16th October 2018

Pre-Application Advice

Demolition of 1No. dwelling & erection of 1No. dwelling.

Mow Cottage Worms Lane Felpham

PROPOSED ELEVATIONS 1:100 @ A1

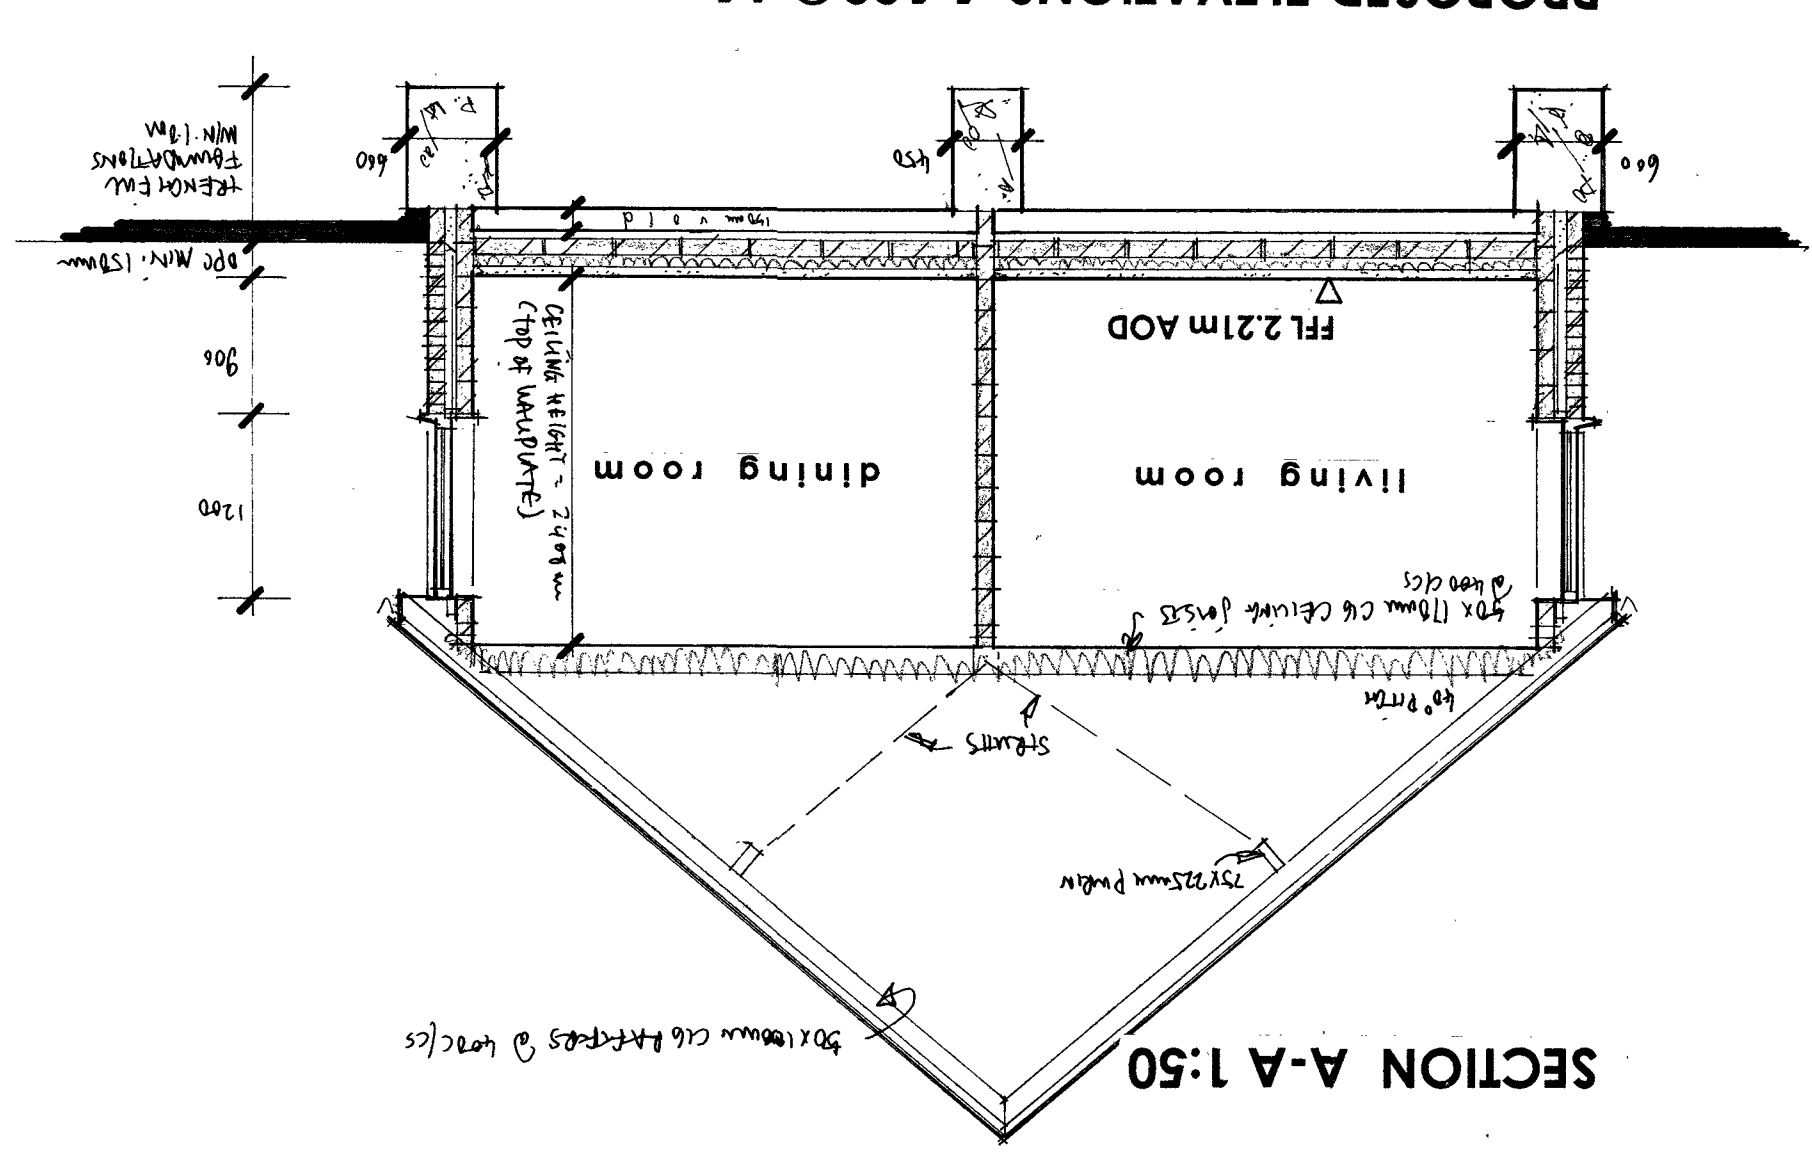
The current proposal as described by the floor plans and elevations is considered to be small in footprint & scale and would be unlikely to result in any harm to this semi-rural landscape, particularly given the existing natural screening to the boundaries and the presence of existing ruined buildings on the site which set the existing scene in visual terms.

The proposal would therefore likely be considered acceptable and in accordance with policies D DM1, D SP1 and also policies ES1 & ES8 of the FNDP.
